November 7, 2024

Robert Webb
City of Albuquerque – Planning Department
PO Box 1293
Albuquerque, NM. 87103

**RE: SAN ROQUE / LA SERENA ADMINISTRATIVE AMENDMENT
COMMENTS RESPONSE FROM CITY STAFF**

1 Exterior Elevation - Front Entry

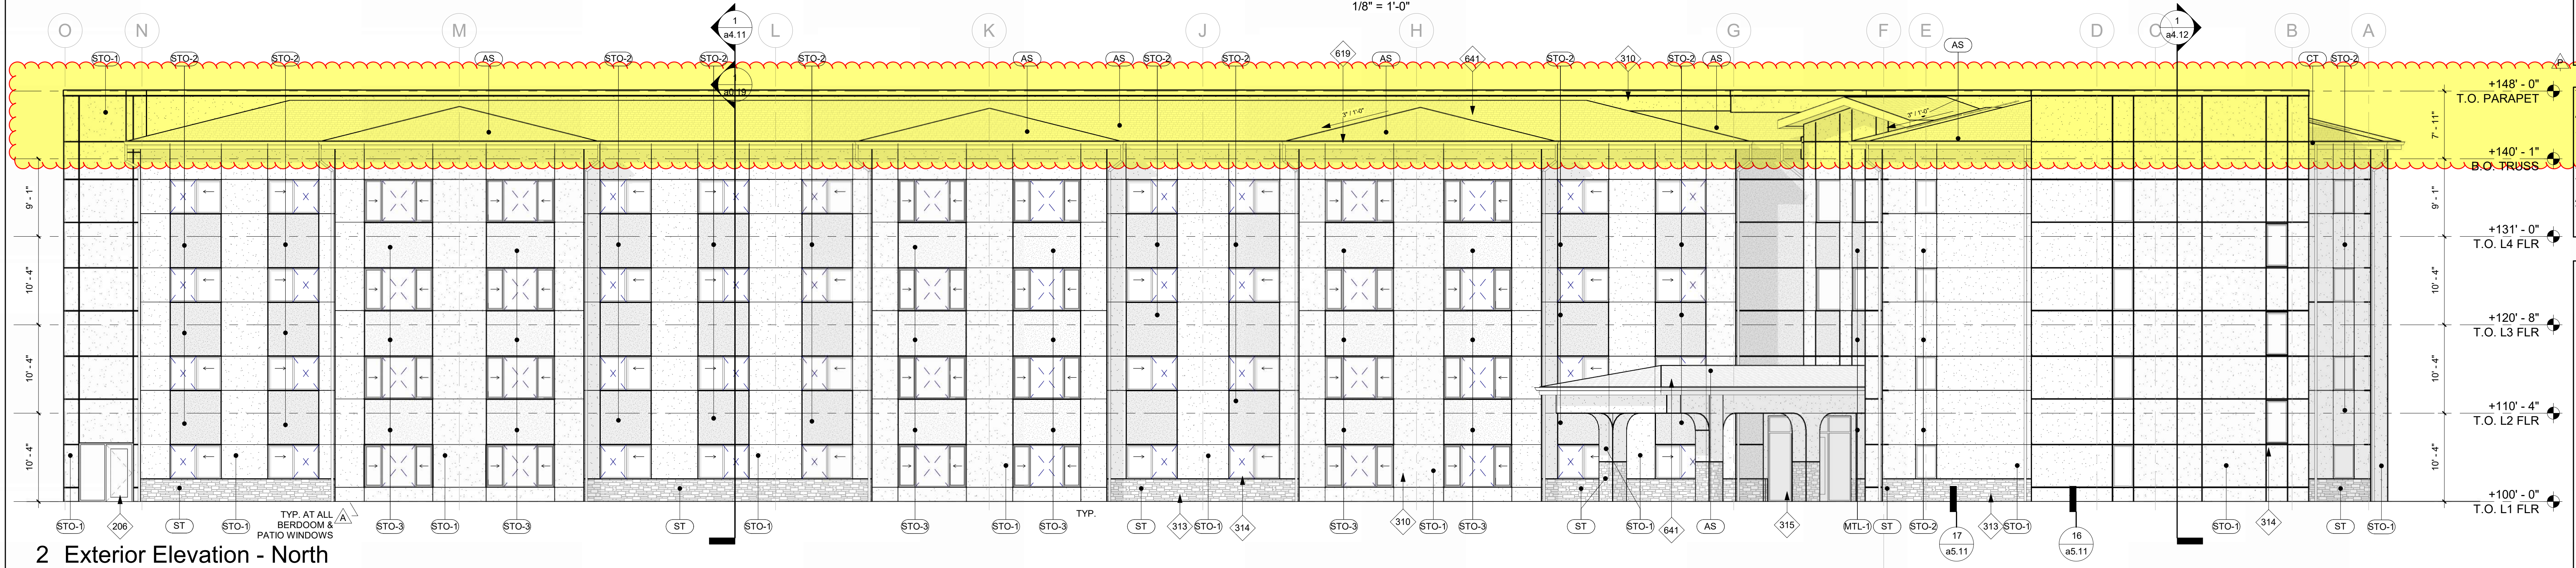
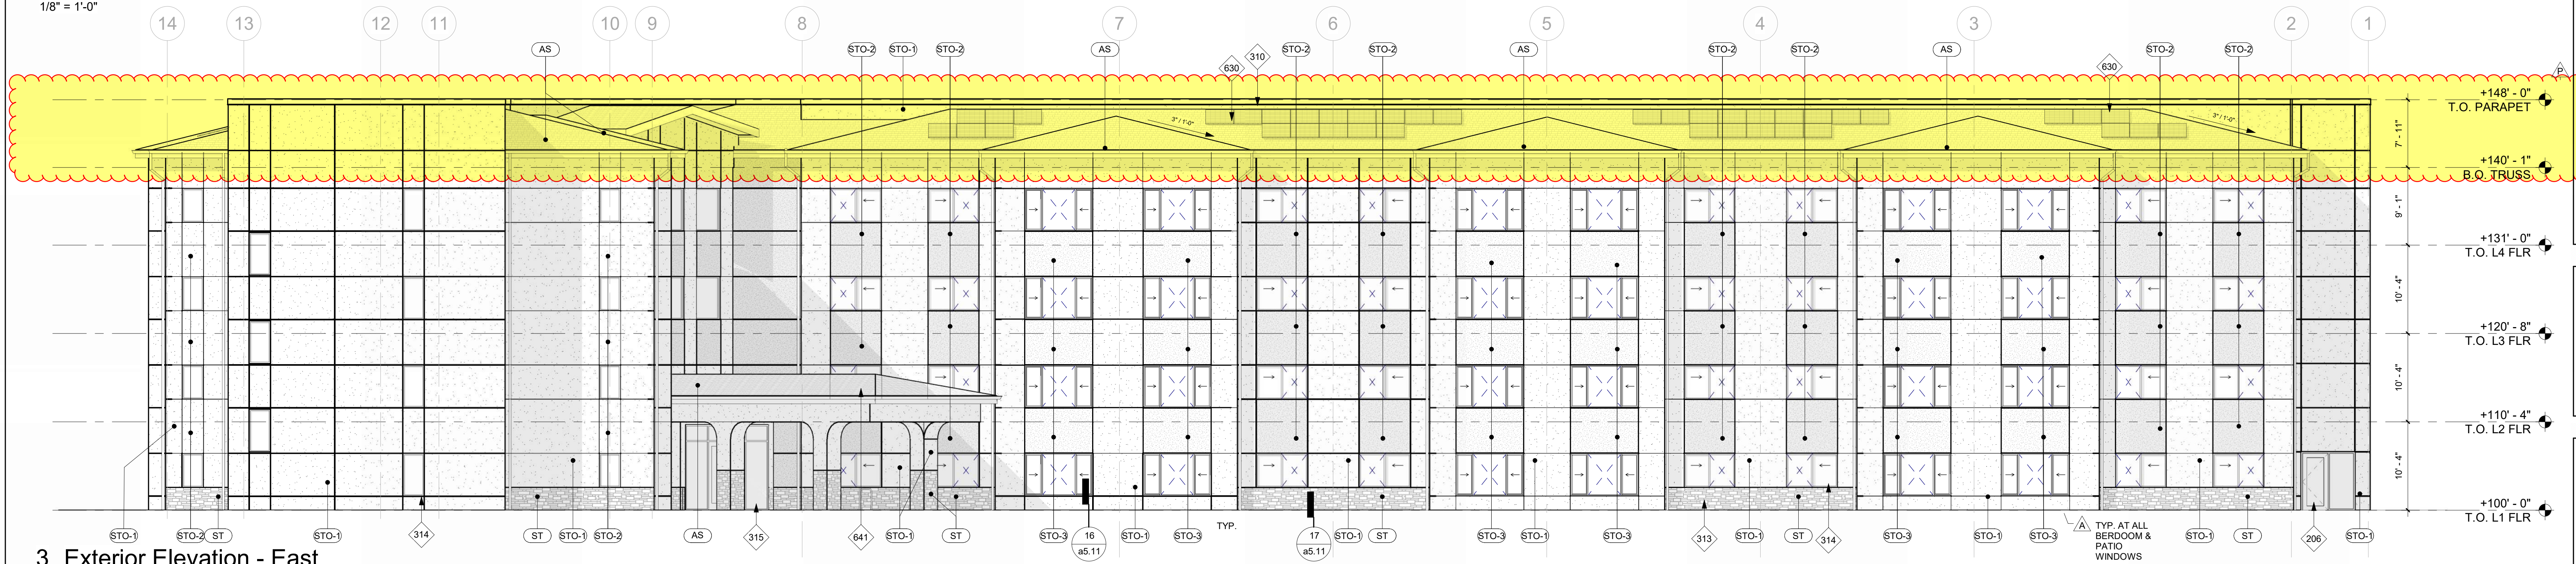
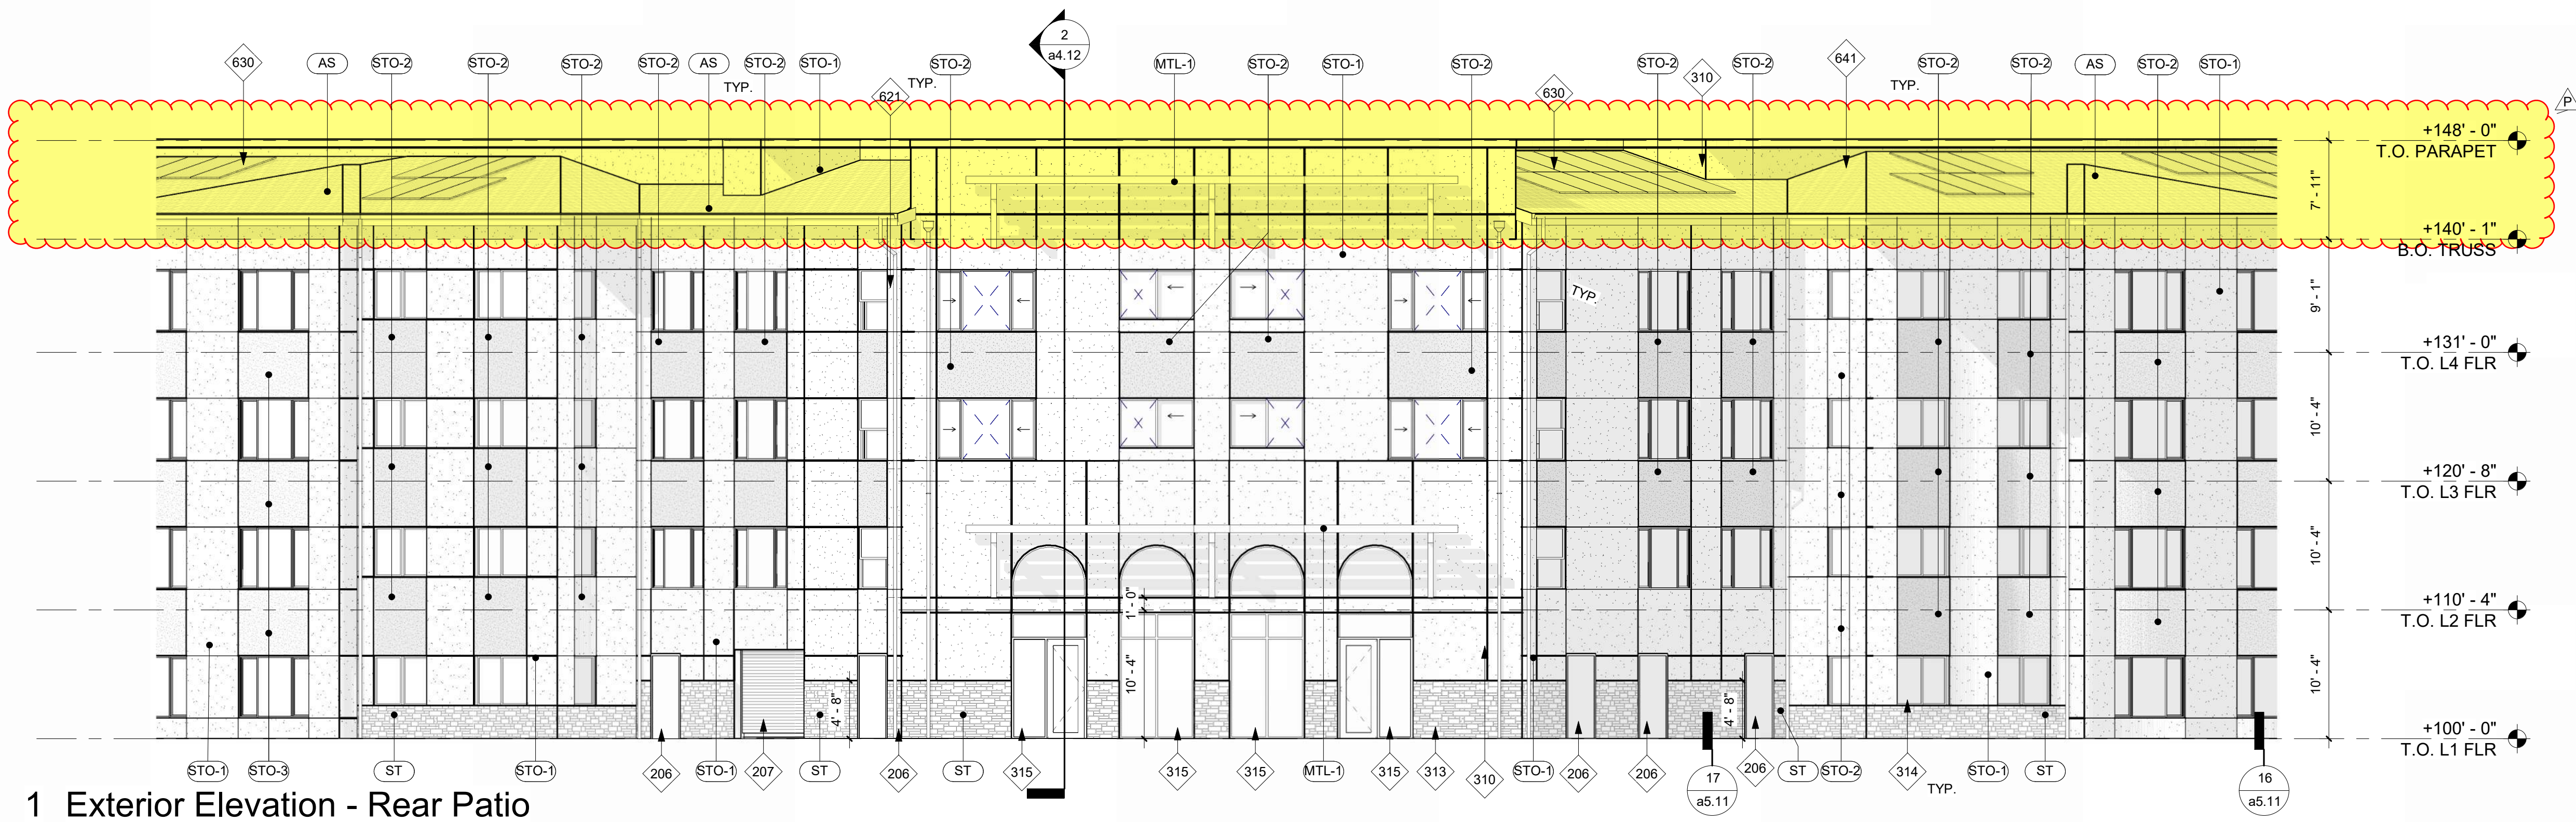
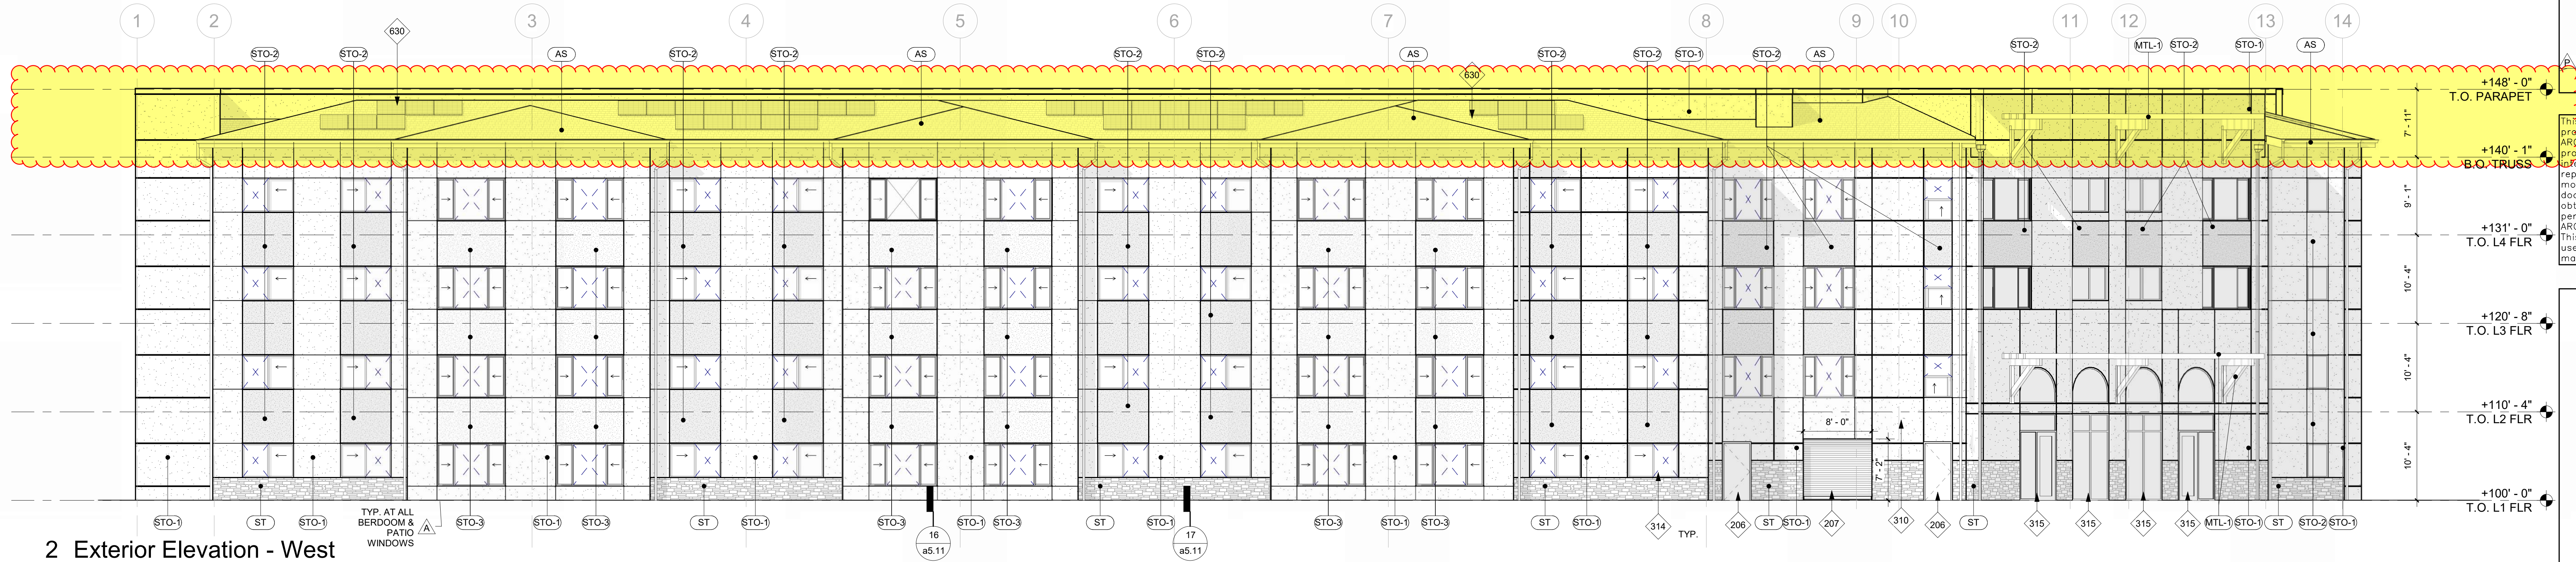
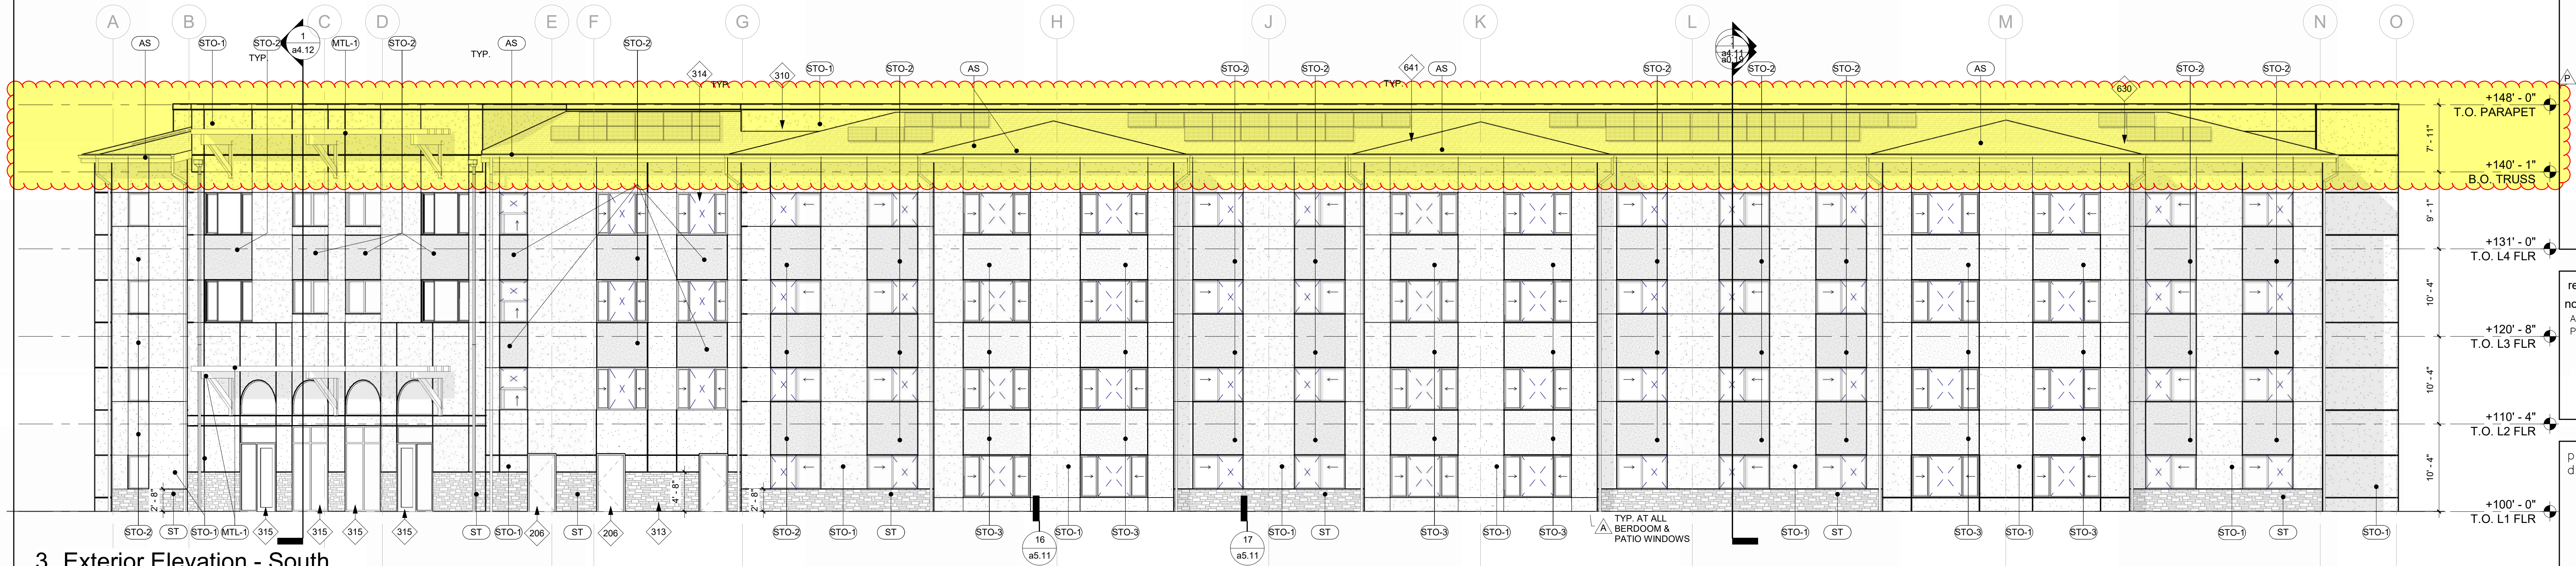
2. **Comment:** In the original letter item #1 mentioned an elevation change and height change. That was since updated to explain that changes to those may not be needed. If it is changing, identify exactly what is being updated and changing. Existing or original is being modified to what? What type of elevation change? What type of height change? What type of screening change?

Comment: Then identify how the change will still be meeting the original approval requirements and/or current

Minor adjustments from floor to floor were made to accommodate the mechanical equipment between floors.

A proposed minor adjustment to architectural elevations is called out on a3.11 & a3.12 as follows:

- a) Parapet heights were previously approved at 47'-1", a revised elevation of 48'-0" is requested. The parapet design will continue to use the materials from the original site plan. This was to provide fall protection.
- b) Center "knuckle" of building roof removed in lieu of a parapet design
- c) Revised roof design at front entry parapet center "knuckle"
- d) Second trellis element added at rear patio parapet of center "knuckle"

The revision to the floor height still meets the height requirements spelled out in the IDO. Per the development height standards of Table 5-1-2, building height for MX-M development is 48-feet. Since the subject site is also within Coors Blvd MT corridor, US-MT-PT area max building height increases to 65-feet.
